**Our Case Number:** ACP-323873-25

**Re:** Kingston Park and Millers Lane - Public Park Urban Realm Project  
Kingston Park & Millers Lane, County Galway

**Re: Objection to Planning Application ref JP61.323873 – Millers Lane, Galway**

Proposed Elevations – South & East

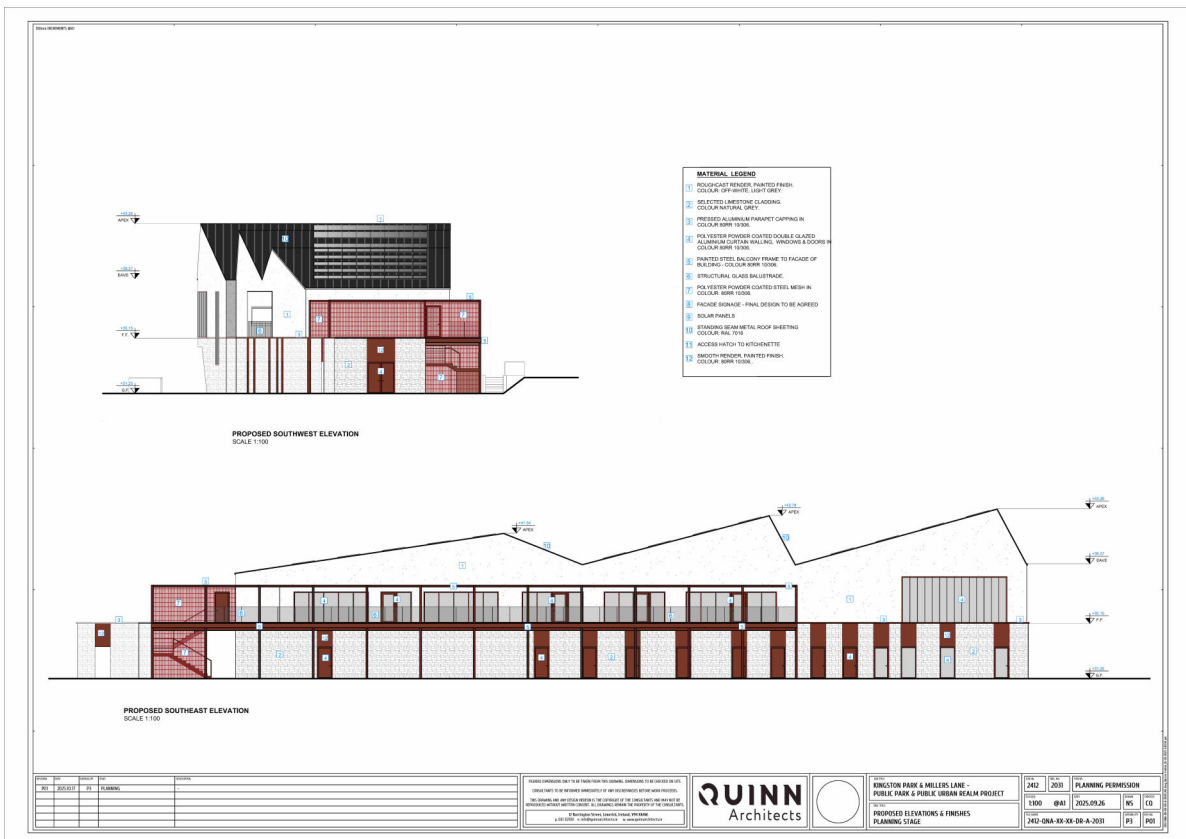
The height of the proposed storage shed, together with its immediate proximity to my property boundary, would create an oppressive and overbearing structure a short distance from my windows. This form and scale of development is not characteristic of residential boundary treatment in the area and would result in an unacceptable loss of outlook and residential amenity.

The proposed large sports building represents a visually intrusive form of development when viewed from neighbouring residential properties, including my own. Its scale, bulk, and massing are disproportionate to the surrounding residential context and would introduce a dominant built form into what is currently an open and visually permeable area.

Figure 8-2 Proposed Site Layout  
\*Extract from DRLA Site Plan Drawing P612-MIL-LD-GA-002

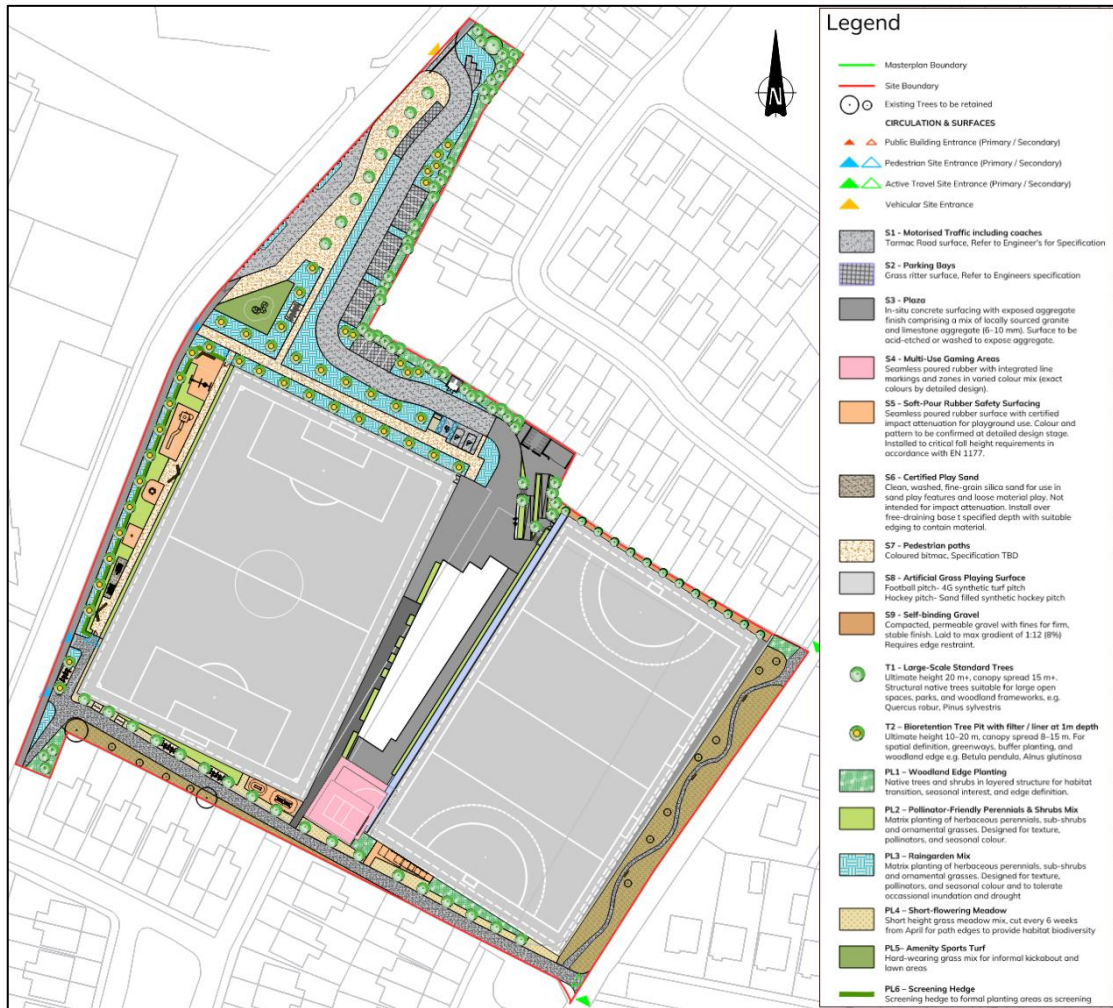
The application proposes only **27 parking spaces** to serve two sports pitches and a large multi-use sports building. This level of provision is wholly inadequate for the scale and intensity of the proposed development.

I note that under **Galway City Council Planning Ref. 21/297**, a hockey pitch development was required to provide **101 parking spaces**, reflecting the level of demand typically associated with such facilities. While site-specific circumstances may differ, the disparity between that requirement and the provision proposed in this application raises serious concerns regarding under-provision.

Inadequate parking is likely to result in overspill parking on surrounding residential roads, leading to congestion, obstruction, and safety hazards, and would further erode residential amenity.
